Yorkshire Green Energy Enablement (GREEN) Project

**Document 8.37 Applicant's Response to the ExA's 8th September
2023 Rule 17 Request for Further Information**

Planning Inspectorate Reference: EN020024

## **Annex 3F.A.4 Tadcaster CSEC Access Point**

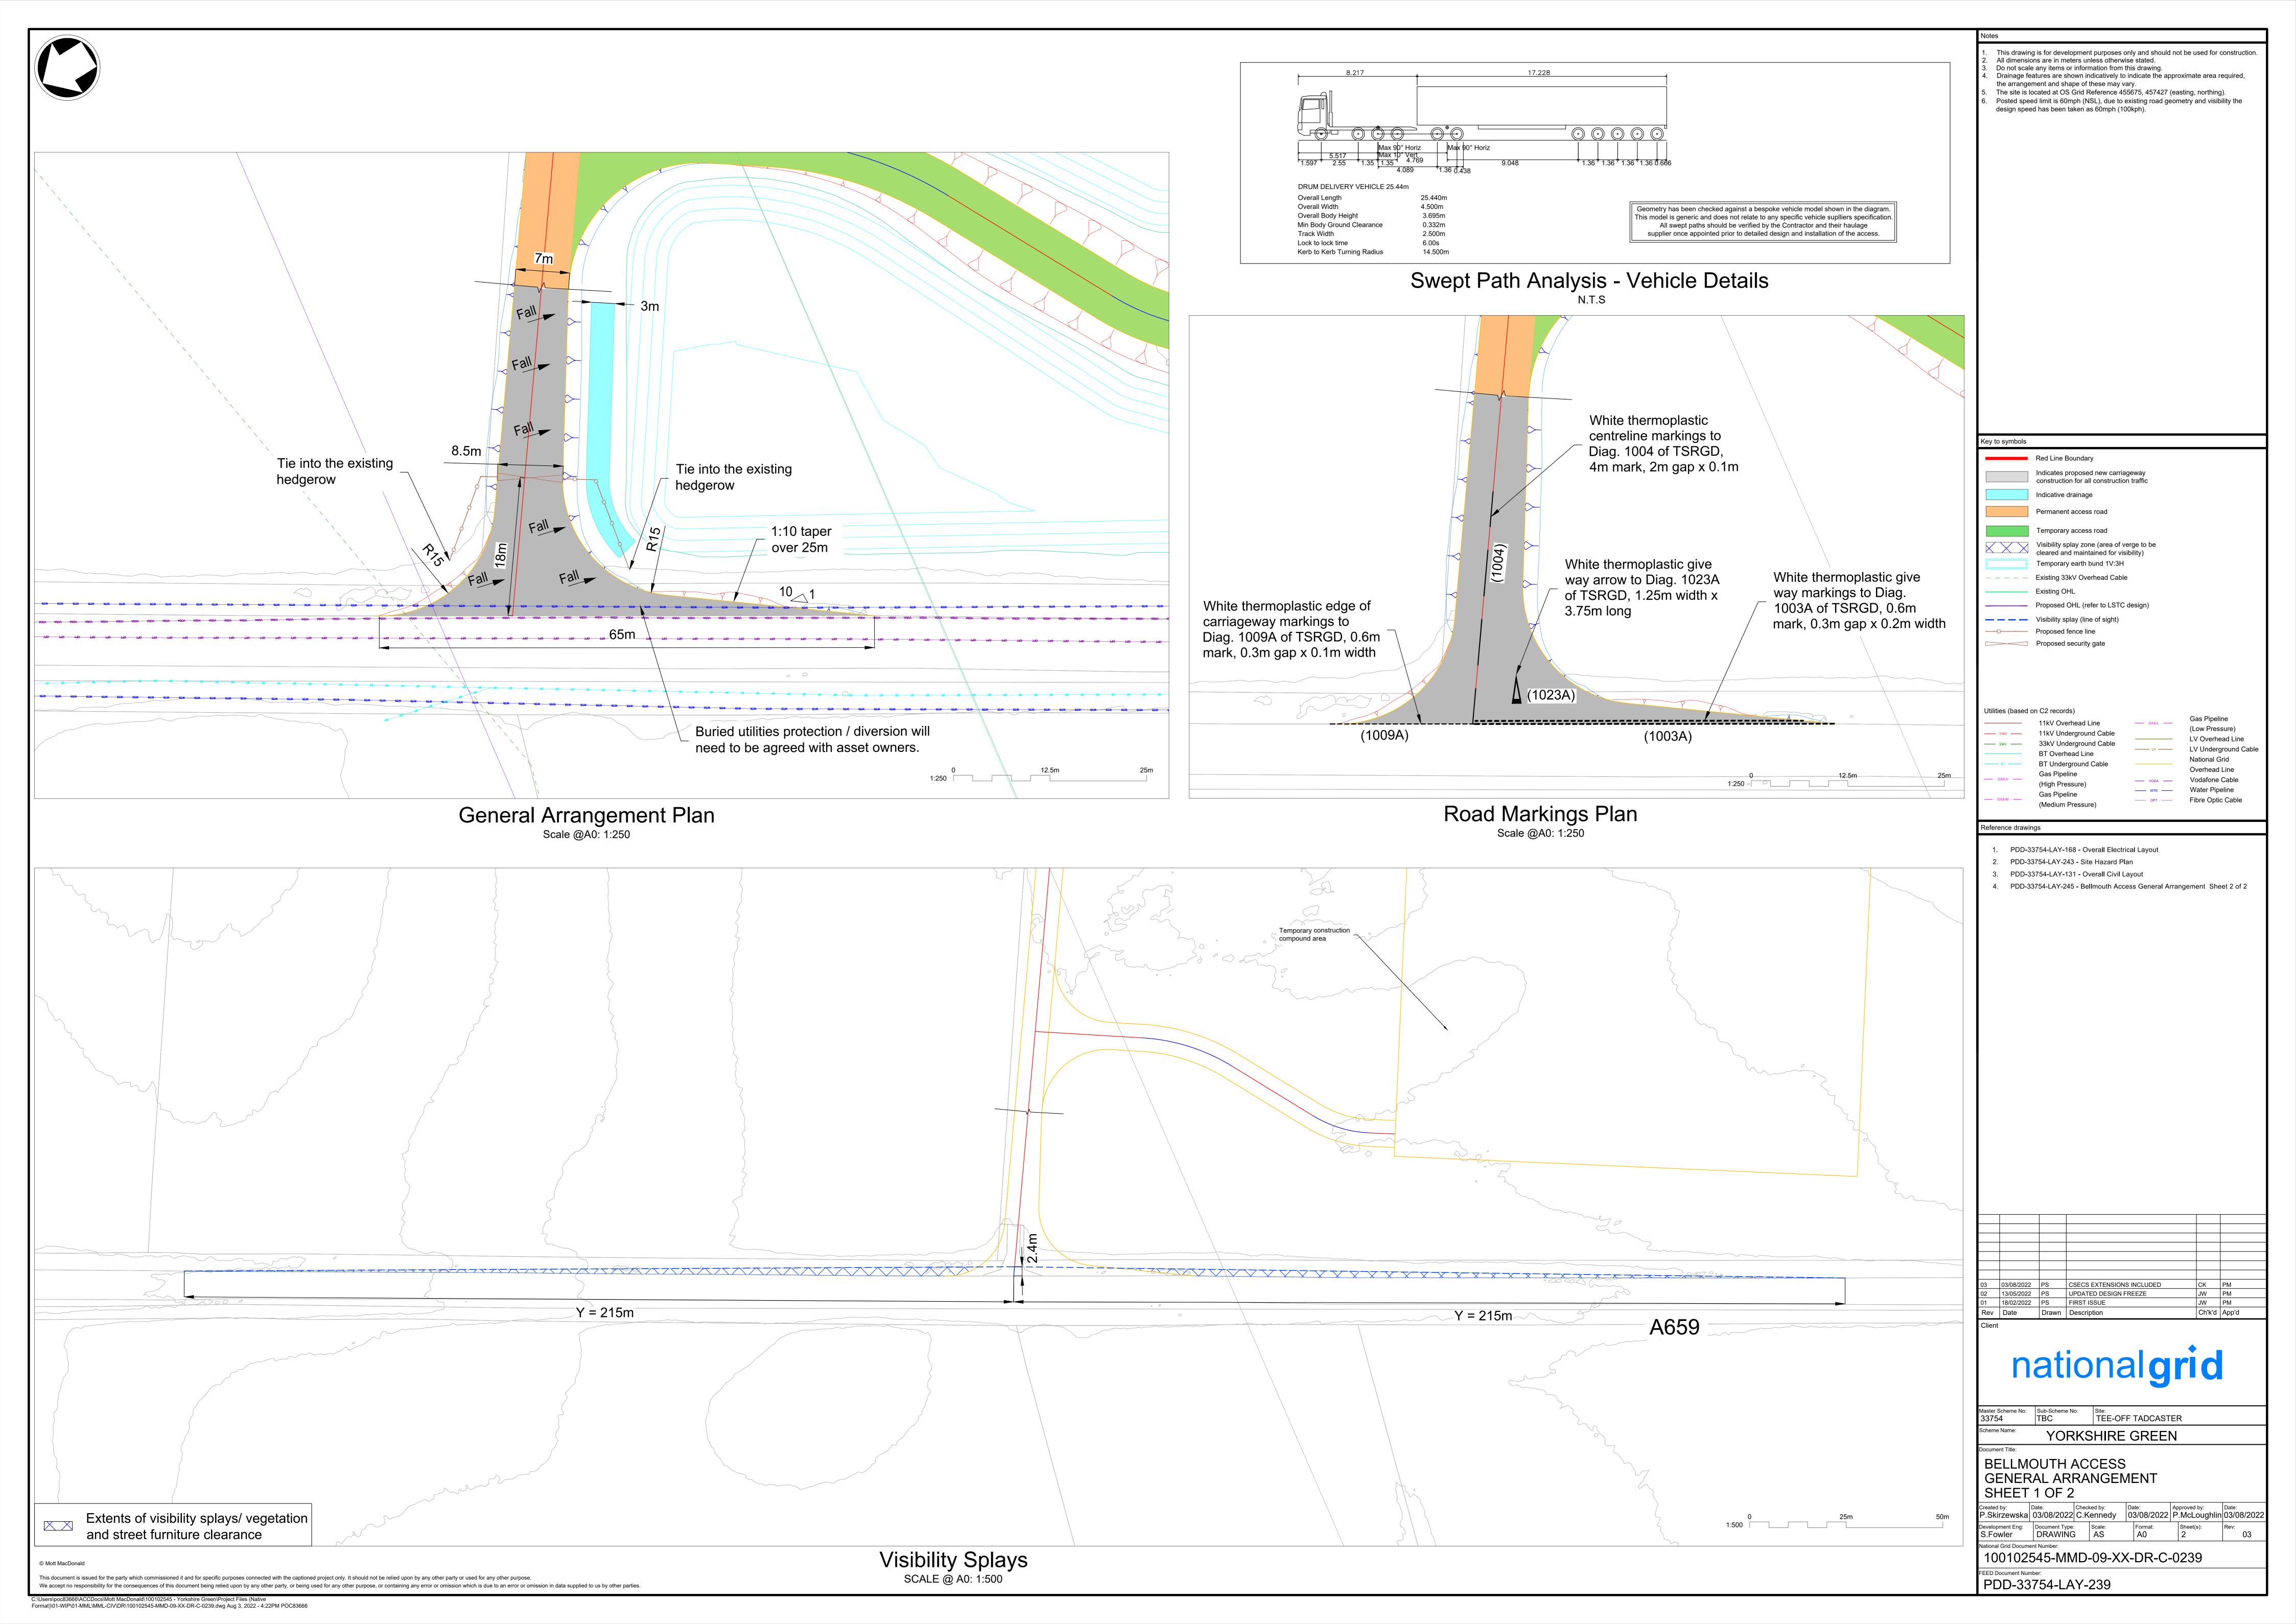
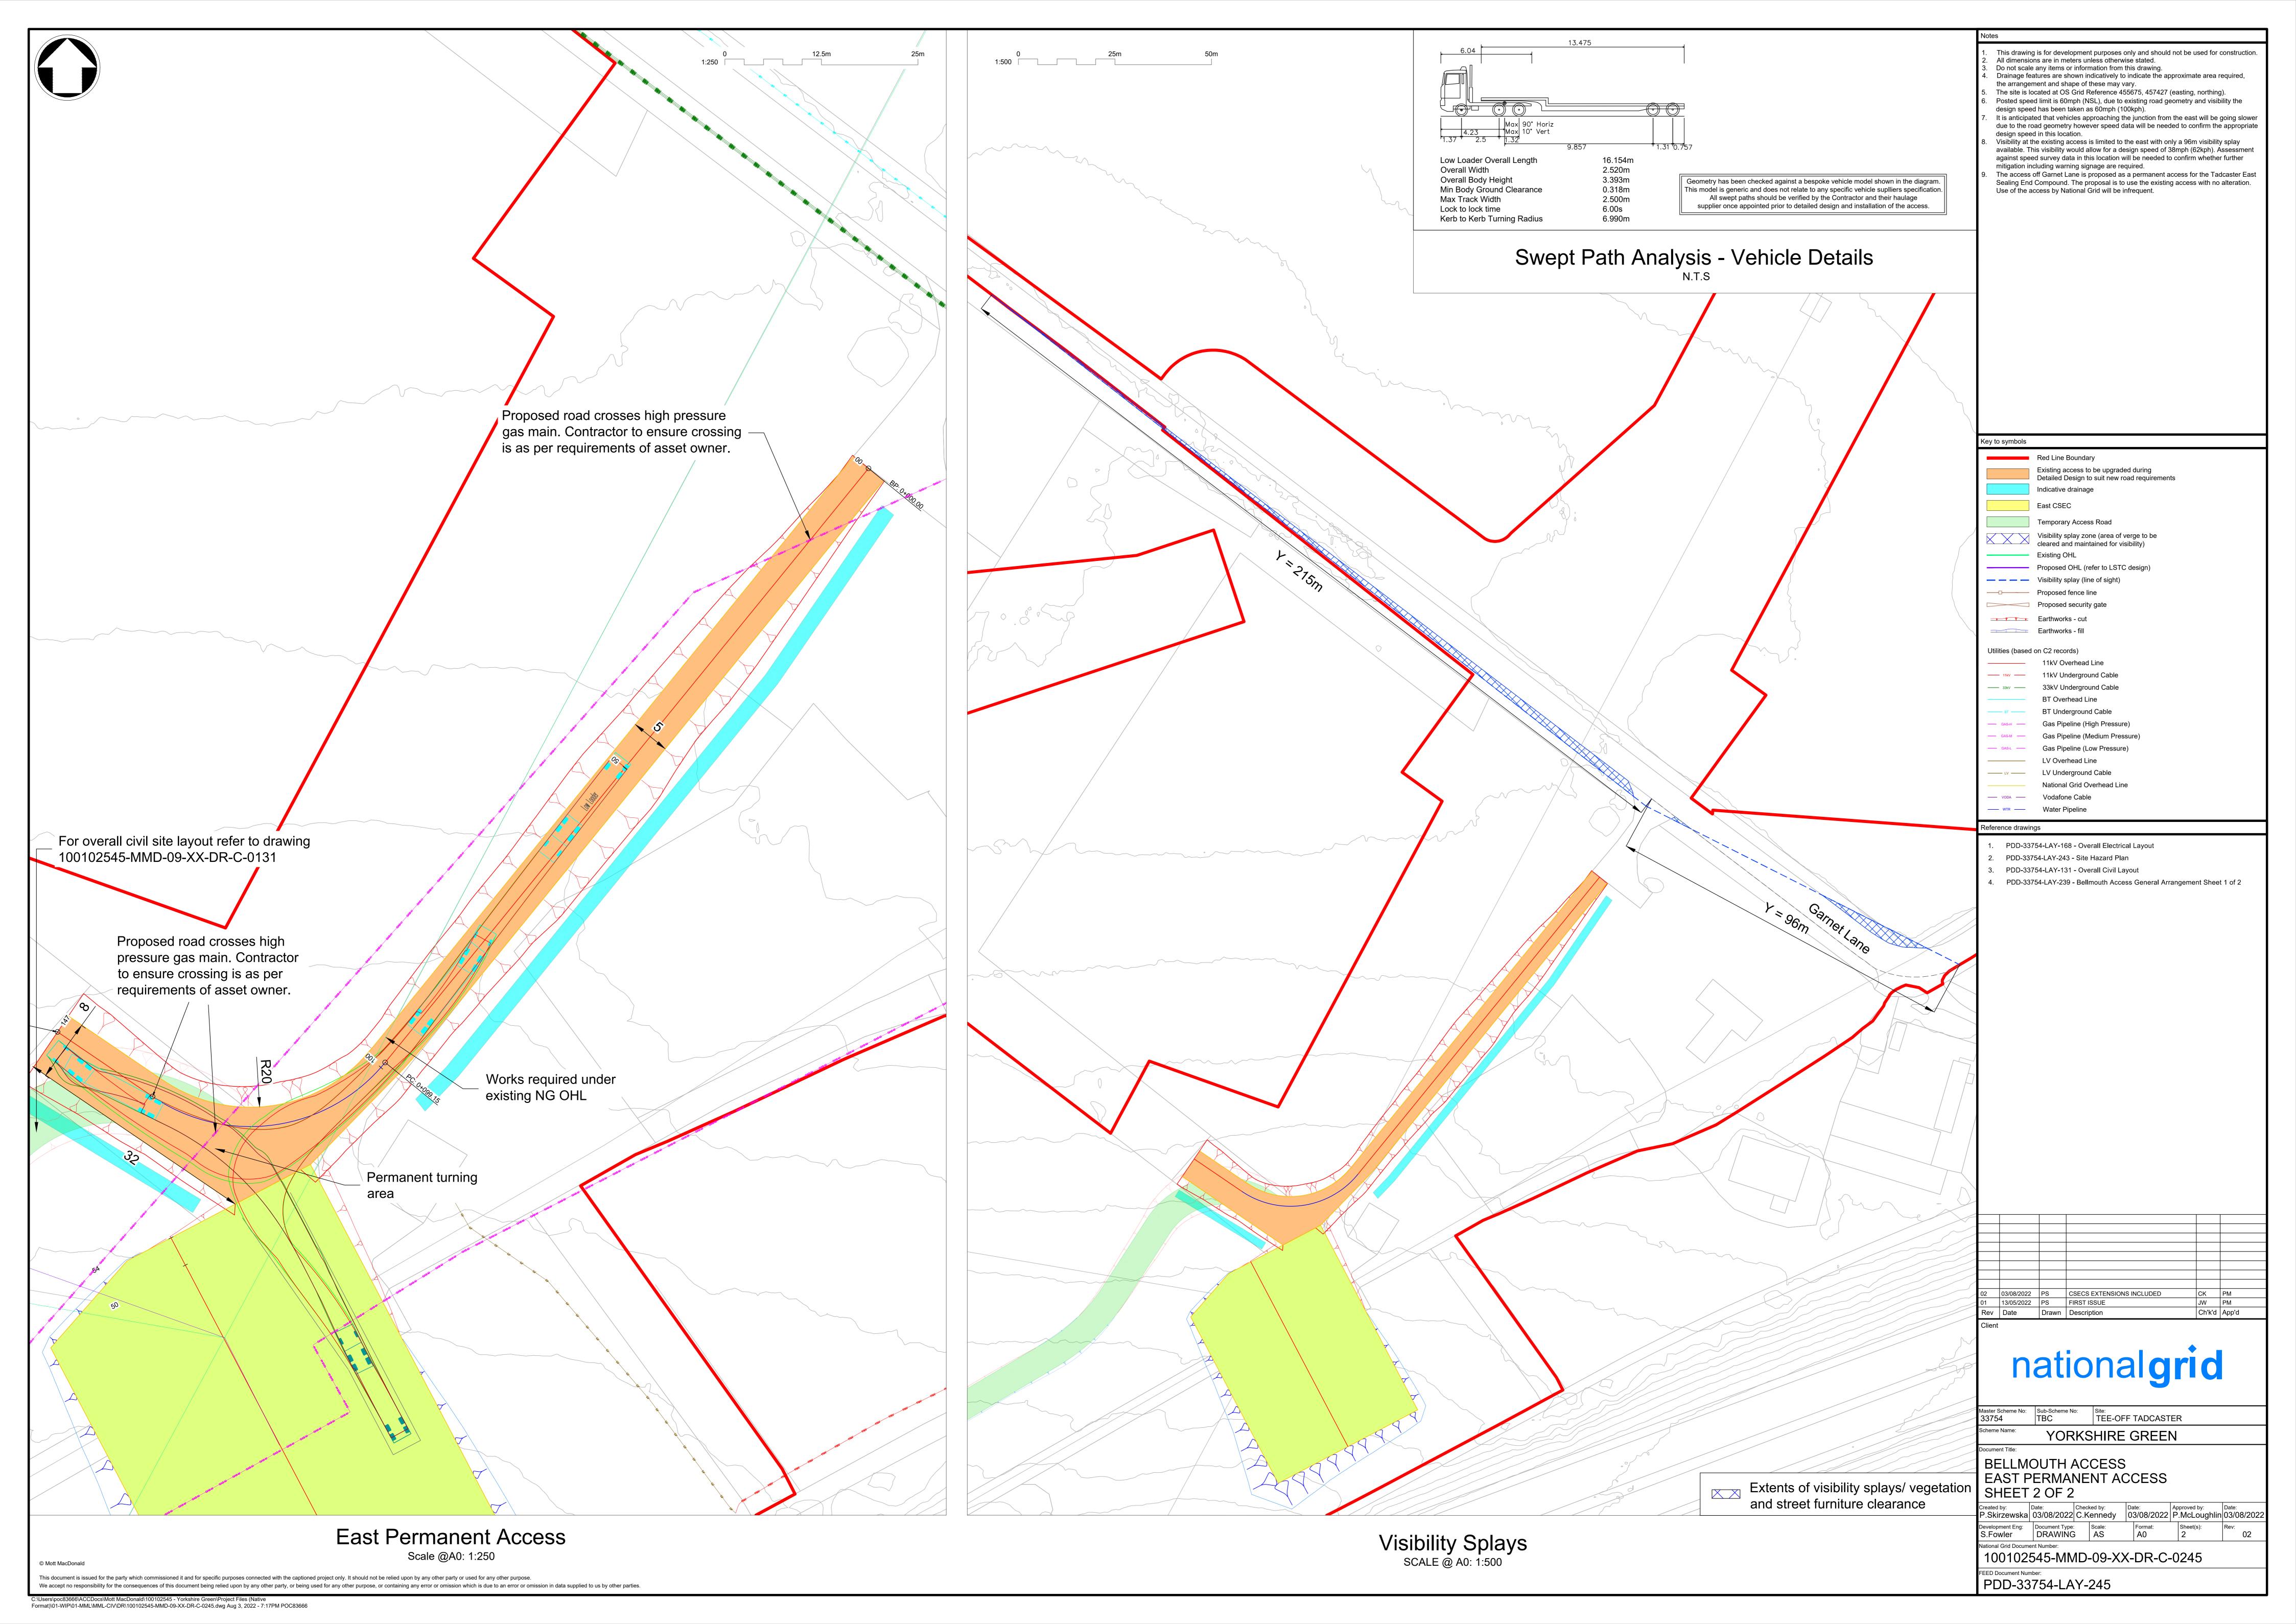
<ul style="list-style-type: none"> • Explain why a track of 7 metres width is shown on the illustrative plan; • If it remains the Applicant’s position that a track with a width of 4 metres could be accommodated, submit a version of the illustrative plan that shows this; and • For the avoidance of doubt, confirm whether the reference to the A361 in the title of Appendix A should instead be to the A659. 	<p>landowner to the Examination, this illustrative plan was also submitted to the Examination in the document referenced above.</p> <p>An access track 7m wide was shown on the illustrative plan as this is the width of the access track included in the application. However as noted above, National Grid considers that a 4m access track could be accommodated but National Grid would require flexibility within the 7m corridor for detailed design of siting and space for drainage of the permanent access. Therefore, National Grid considered it suitable for the illustrative plan to be provided based on the worst case scenario.</p> <ul style="list-style-type: none"> • <u>If it remains the Applicant’s position that a track with a width of 4 metres could be accommodated, submit a version of the illustrative plan that shows this.</u> <p>National Grid has prepared a further Illustrative Plan provided in Appendix B to this document, to provide a representation of what the options may look like based on a 4m wide access. However, this is based on the same dimensions of the bellmouth as shown on the 7m wide access arrangement with the permanent access tapering off to 4m beyond the gate as these remain illustrations prior to detailed design.</p> <p>As detailed above because flexibility is required for siting and space for drainage, this plan is only an illustration and does not represent the exact location of where the access would be located within the Order limits. National Grid has not been able to engage with the landowner on this matter as they have been unavailable for a meeting and no reply was received to National Grid’s emails of 16 August and 5 September 2023 providing the illustrative plan. Therefore National Grid has not been able to progress the development of a potential solution further with the landowner. National Grid will continue to seek to engage Mr Watson and his agent further on the details of the detailed design of the permanent bellmouth and permanent access arrangement should</p>

<p>consent be obtained as it is in National Grid’s interest to reach a solution that works for both parties to secure the access from fly tipping.</p> <ul style="list-style-type: none">• <u>For the avoidance of doubt, confirm whether the reference to the A361 in the title of Appendix A should instead be to the A659.</u> <p>Yes, that is correct the reference in the title should be to the A659 and not the A361. This has been corrected for the 4m access version of the illustrative plan submitted at Appendix B. National Grid has also updated the illustrative plan provided in response to Action 6 at Appendix A of the Applicant’s Deadline 7 Response to CAH2 Hearing Action Points (Document 8.29.5) [REP7-046] submitted at Deadline 7 and this is provided at Appendix C of this document. In doing so National Grid has also corrected a typographical error.</p>
--	--	--
